N.C. DEPARTMENT OF ENVIRONMENT AND NATURAL RESOURCES
DIVISION OF ENVIRONMENTAL HEALTH

Comment Addendum

COUNTY: Harnett
NAME: Matthews Landing ID: _____
STREET: _____
CITY: _____ DATE: 8/25/25
STATE: _____ ZIP CODE: _____ TIME: _____

**Detail - Vacuum Inlet Detail**  
1" = 1'-0"

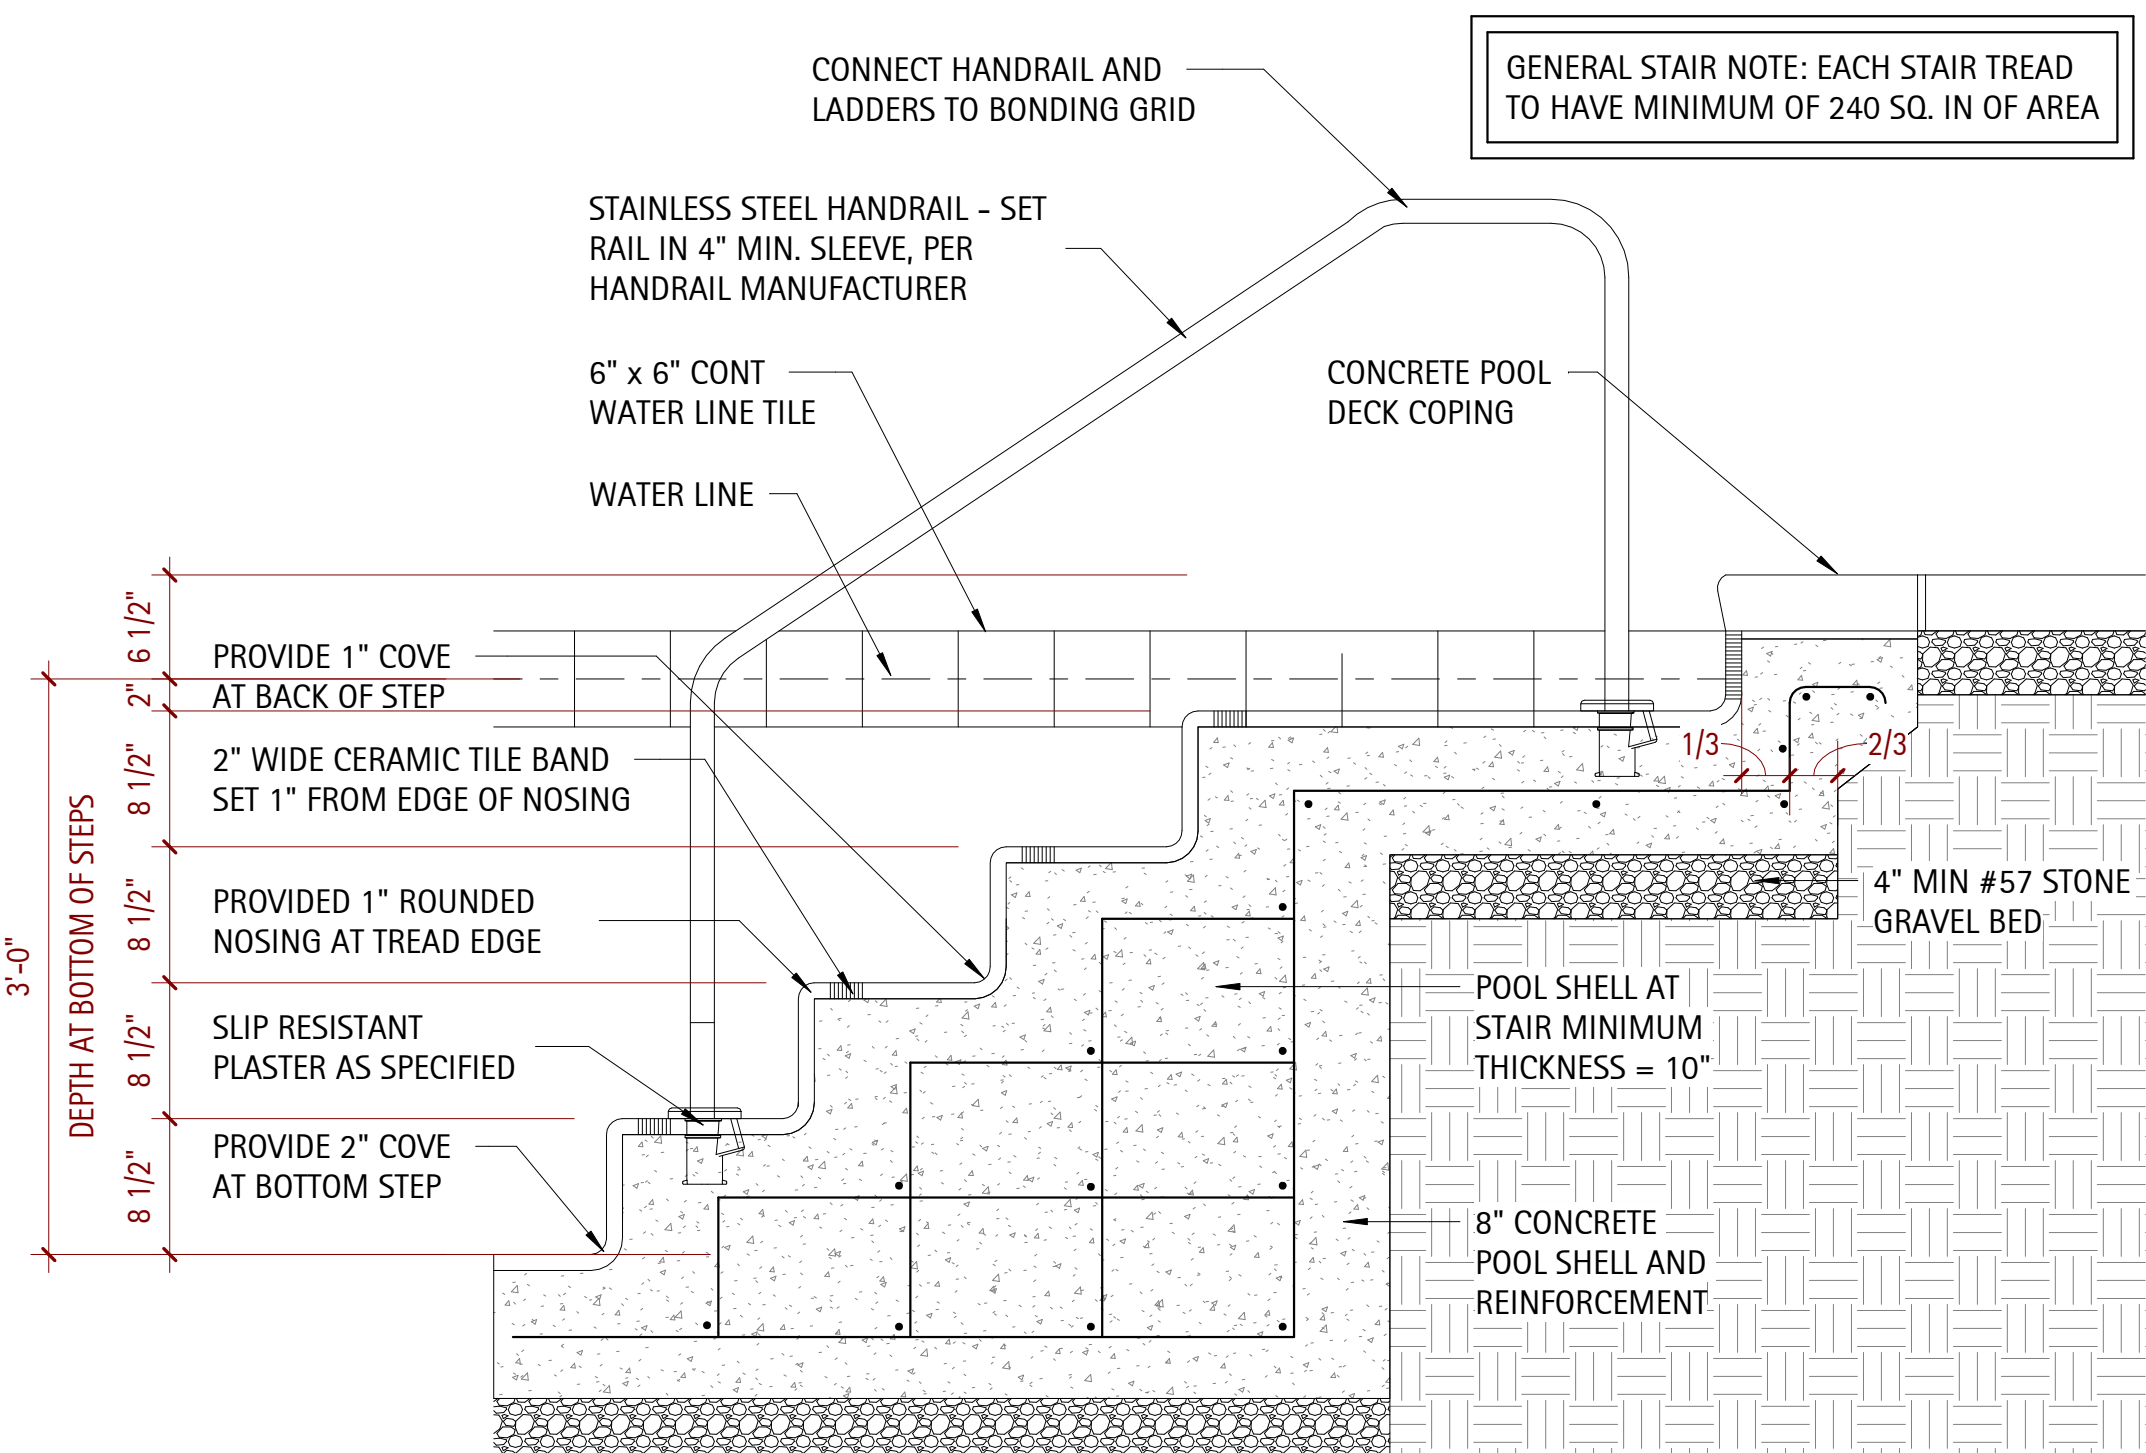
- Autofill line not present
- Vac line @ 21" w/out deck/bullnose - should be $\leq 18"$ total depth
- 2" line present on return line b/t T's - should be 3" (near main fbb)
- return line not connected to inlet @ sun shelf
- 2" line present between skimmers - should be 3" @ skid/steps
- overflow line plumbed to return pipe - overflow stubout too low - overflow should be plumbed to channel drains or to daylight - stubout should be on tile line above operational H₂O level
- move or adjust electrical conduits for light junction boxes outside the fence so that no foothold is created.
- Find bubbler lines & connect them properly
